**ADC Planning Consultation
Response from the Historic Buildings Adviser
AMENDED**

Application Number	R/125/15/L
Address	Elm Farm, 34 The Street, Rustington, BN16 3NX
Description	Application for Listed Building Consent for refurbishment of existing house & creation of an additional annexe within the existing building envelope.
Case Officer	Anita Gardner
Site Visit	Previous

D4 - East Elevation

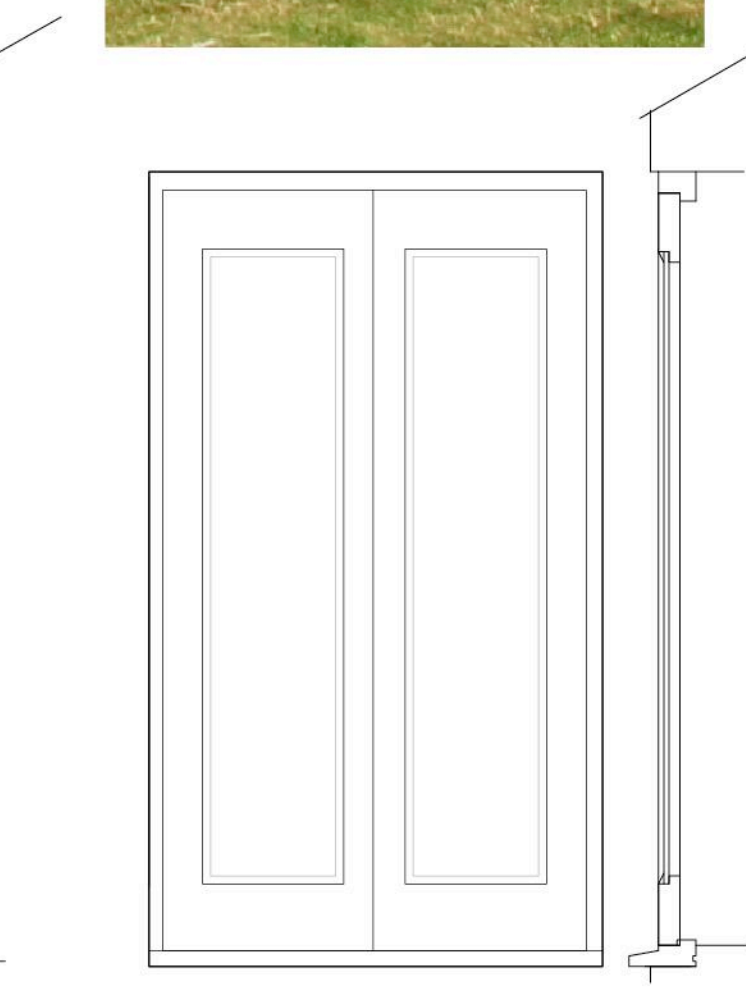
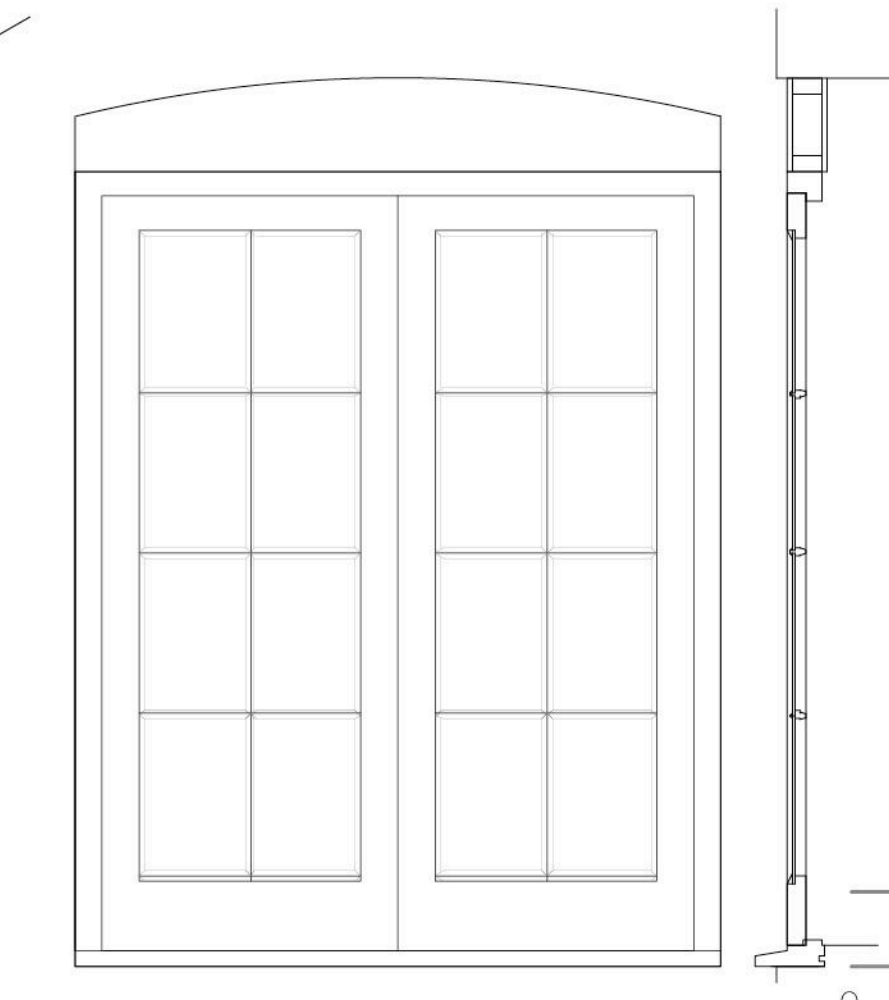
Whilst this scheme is acceptable we would recommend amending the design of the proposed French doors in the east elevation. These would appear more sympathetic with three horizontal glazing bars to mimic the front.
